**Addendum to Building Permit Application  
822-824 Washington Ave Portland**

**Laura Burke**  
**[lburke1@gmail.com](mailto:lburke1@gmail.com)**  
**207-653-5405**

laura top desk

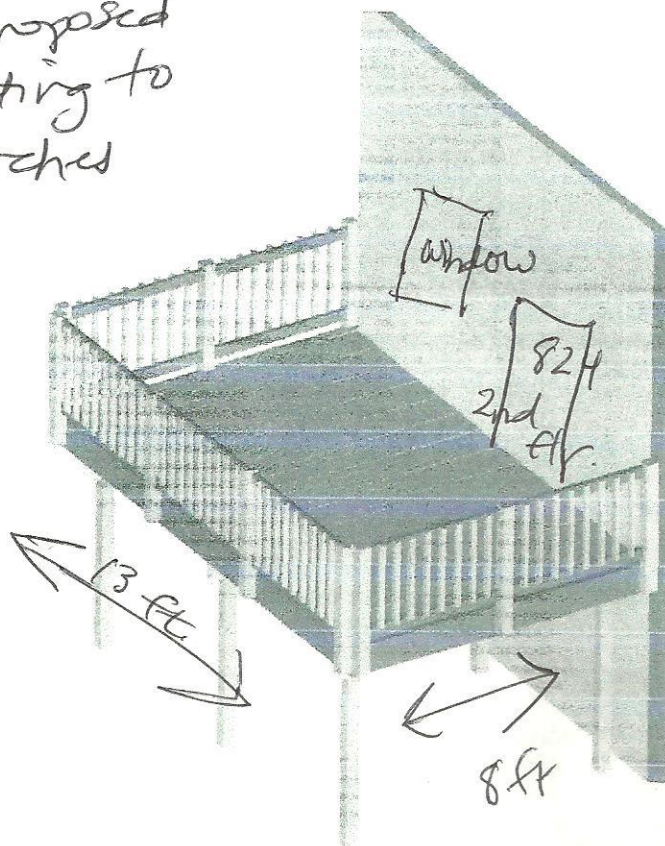
Please note the existing footprint of both the lower and upper porch to remain the same. The only work being done is replacing the existing decking on the upper porch as well as replacing all handrails. Handrails will be built according the Section 312 Guards of the IRC 2009 including a 36" guardrail height with opening limitations of the guardrail to meet Section R312.3 Opening Limitations of 4" on center.
